Tel: 01895 250230
Case Officer: Nicola Taplin
Email: ntaplin@hillington.gov.uk
Date: 29th September 2020
Our Ref: 25767/PRC/2020/157

RE: Proposed new flats comprising 9 dwellings
SITE: 72 Harefield Road Uxbridge

I refer to your request for pre-application planning advice dated 27.7.20 relating to the above development. The advice provided is based on the following drawings and documents issued to the Local Planning Authority for consideration:

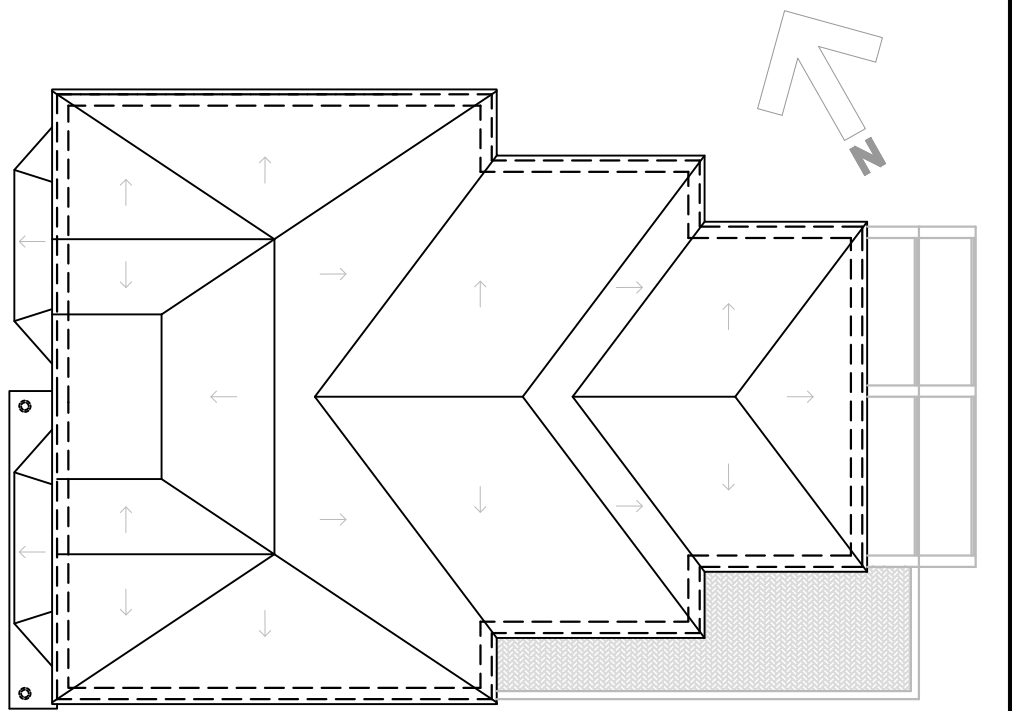
Floor plans at a scale of 1:100 would need to demonstrate compliance with the specifications set out in the above document. Particular attention should be given to the special requirements, and clear access zones, within the living areas, bedrooms and bathrooms. The indicative plans submitted at this stage indicate that the passage ways leading from the lift and stair core would be too narrow to comply with the policy requirement.

The Access Officer's comments about the indicative plans submitted indicating that the passage ways leading from the lift and stair core would be too narrow to comply with the policy requirements should also be addressed.

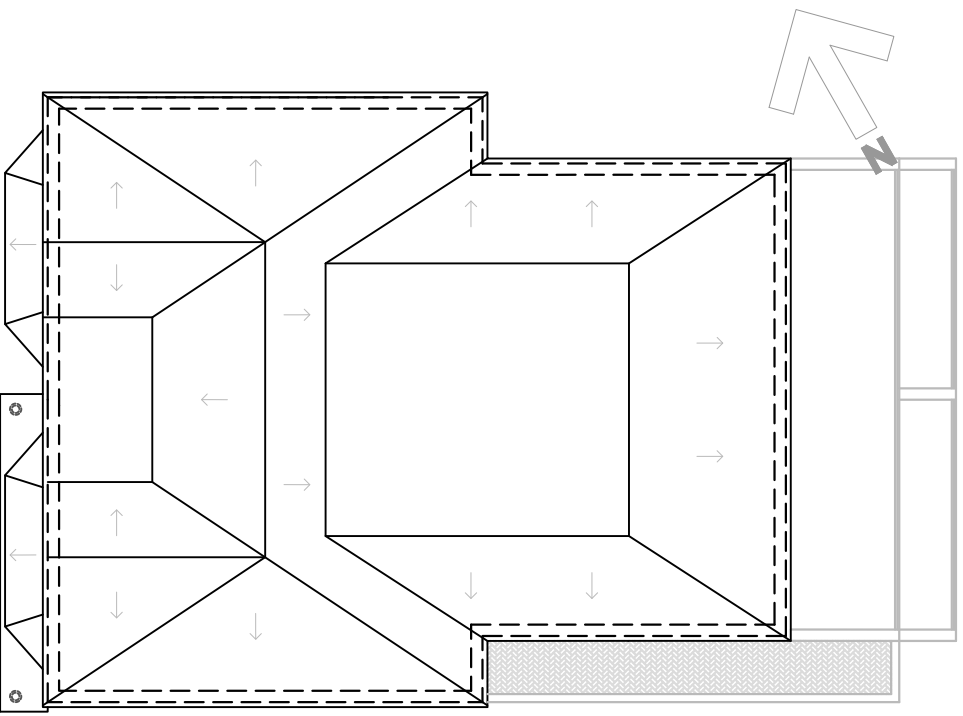
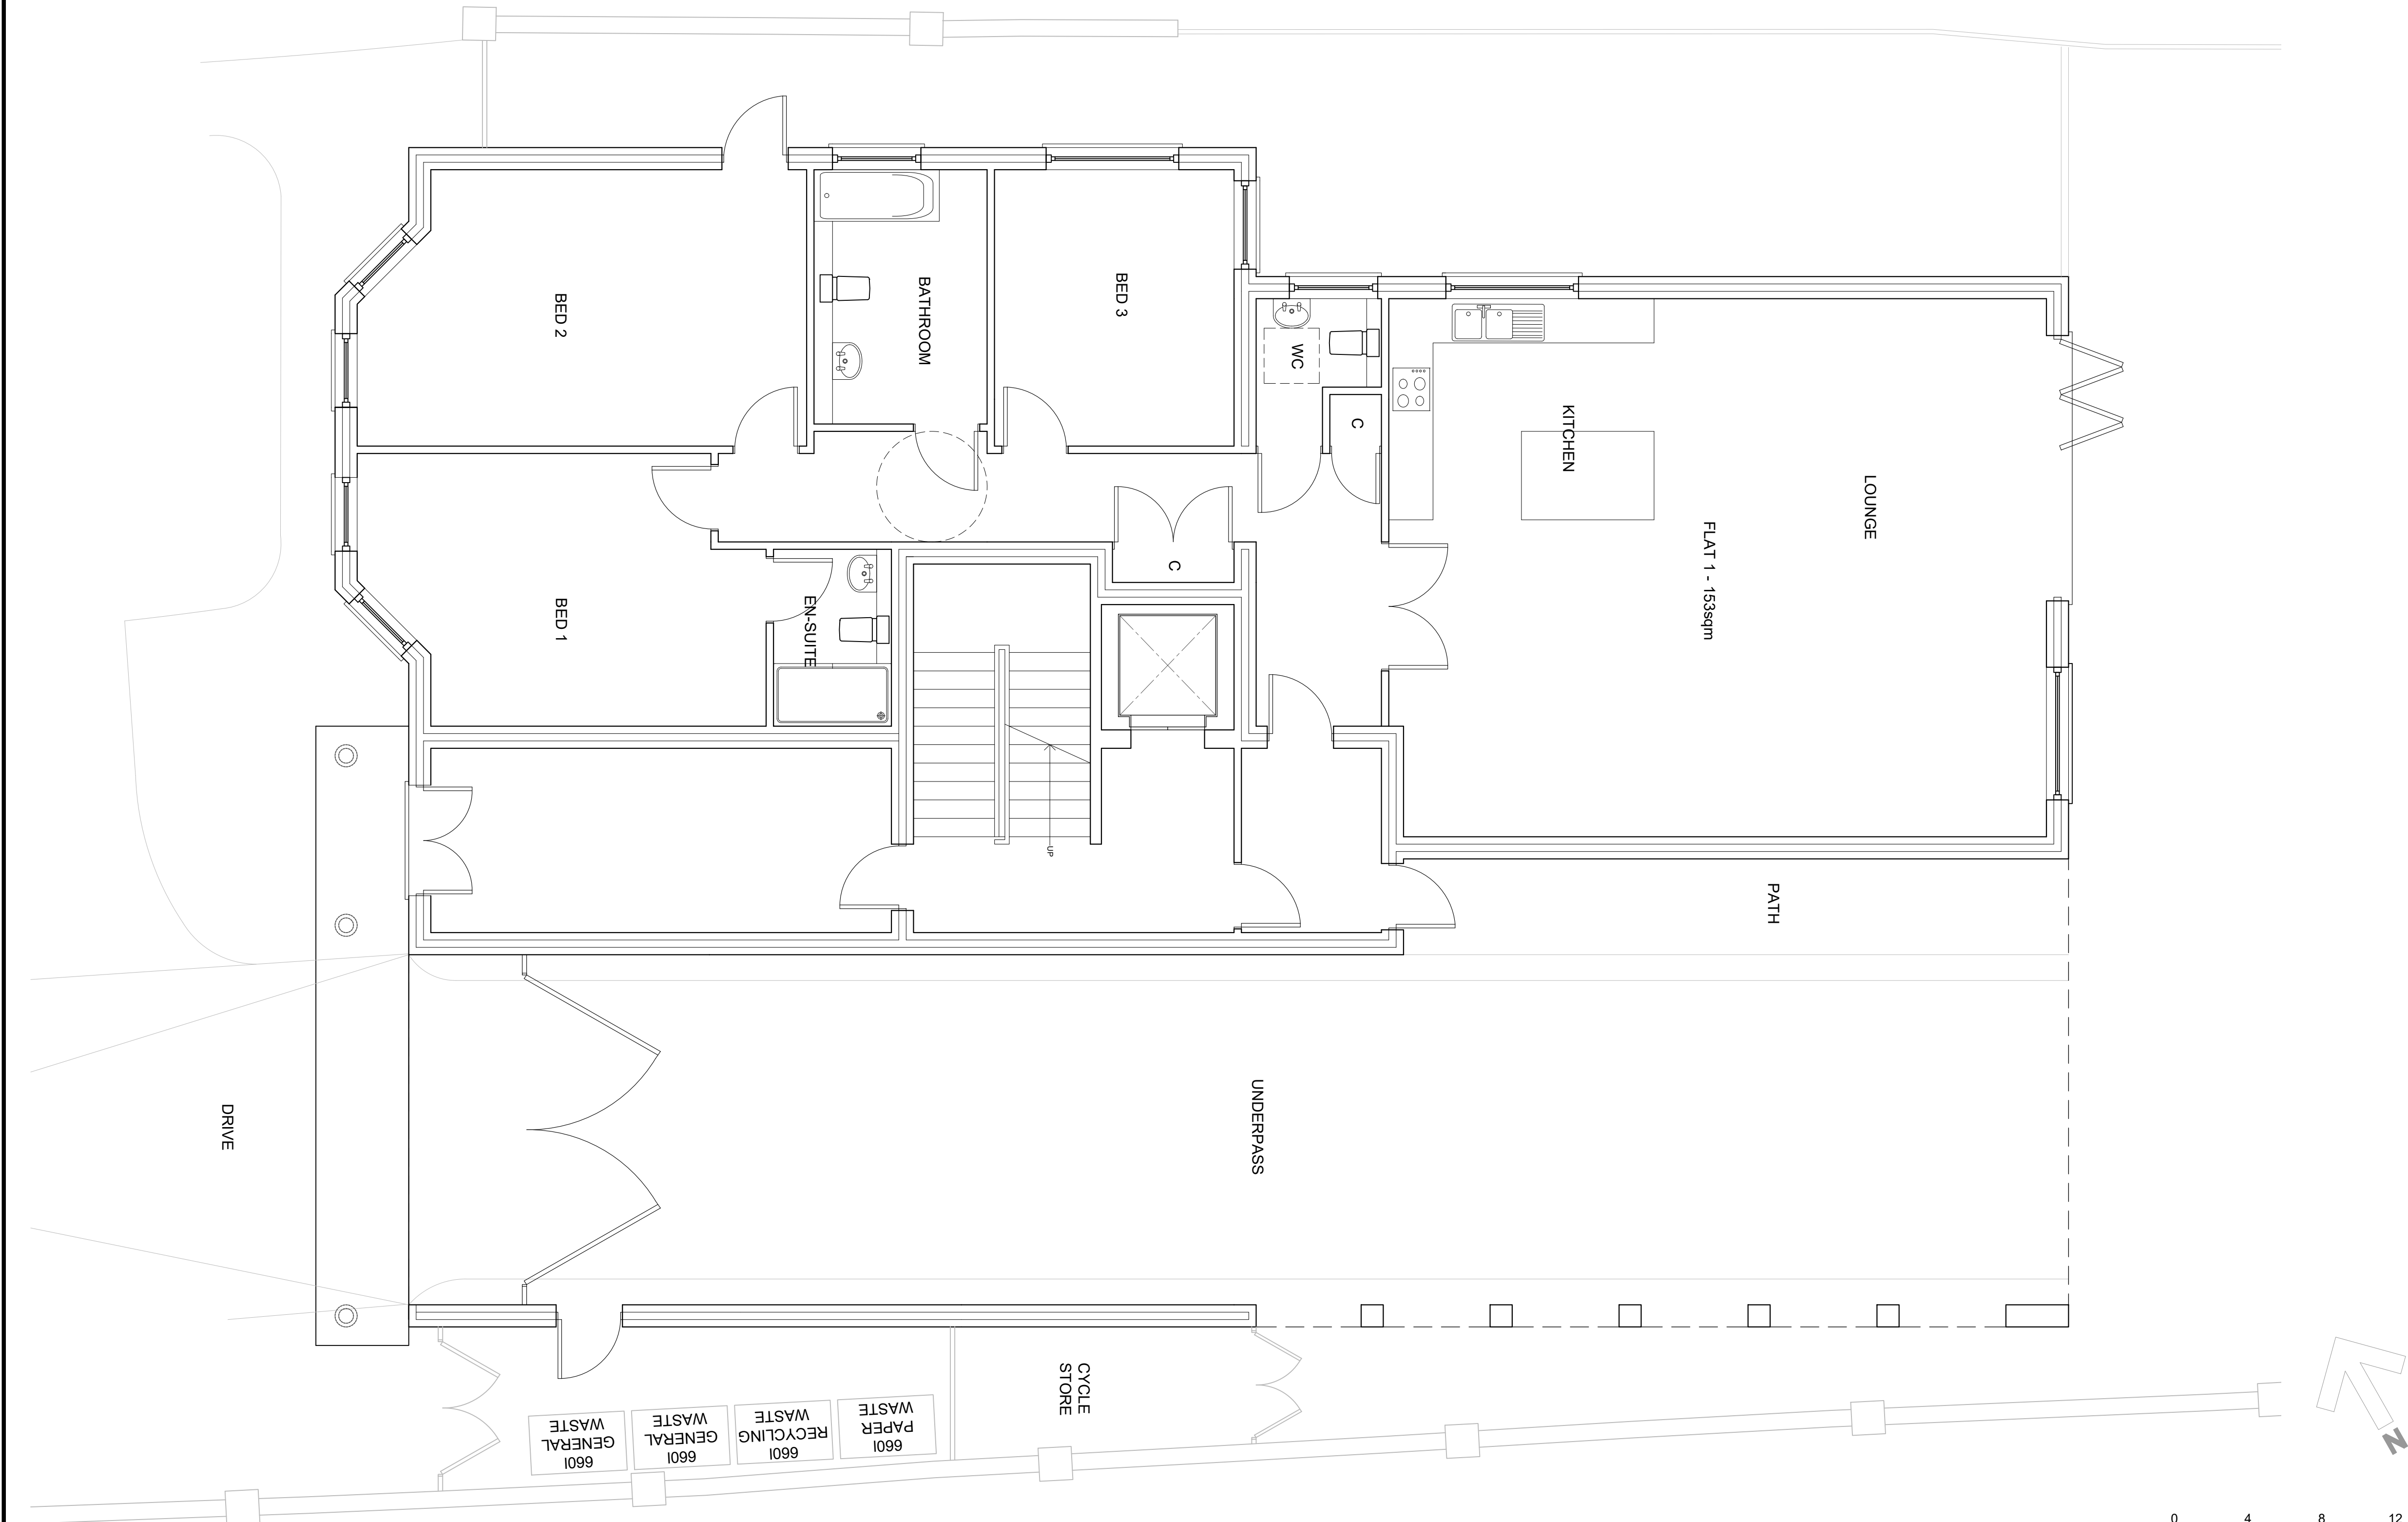
The proposed building would not appear to contravene a 45 degree line of sight from the rear windows. The increased bulk of the proposal extending so significantly beyond the rear of the neighbouring building at an increased height would result in a significant sense of enclosure and over dominance. The adjacent flats to the south are sited 2.2m off the boundary with the application site. The proposed building would project 6.5m to the rear of these flats at upper levels which would not, on balance, have an unacceptably dominating impact. Number 74 Harefield Road has 4 windows in its flank elevation of the outrigger to the rear, two at ground floor level and two at first floor level. The applicant has confirmed that the windows serve a toilet / bathroom and secondary bedrooms only. It is considered on balance, that the proposal would not result in an unacceptable loss of amenity to occupants of flats in both adjacent sites.

The submitted floor plans indicate the principle windows would face the front and the rear of the site. The side windows appear to serve non habitable rooms and should be obscure glazed and non opening below 1.8m. There are proposed rear facing balconies and these would also need to be screened by 1.8m high privacy screens along the sides. It is therefore considered there would be no significant loss of privacy to the adjacent properties.

There should be a provision of at least 1 secure and accessible space for each of the 2 bedroom flatted units with 2 spaces for any of the 3 bedroom provisions in order to conform to the adopted minimum borough cycle parking standard. A cycle store is indicated but no quantum is specified hence the required level of provision needs to be demonstrated.

The proposal will involve significant excavation required to accommodate road level access and parking, together with a large parking court in the rear garden, with a significant amount of tree loss. There is a concern about the amount of residual accessible and attractive amenity space that will remain due to the car parking arrangement and the changes of level across the site.
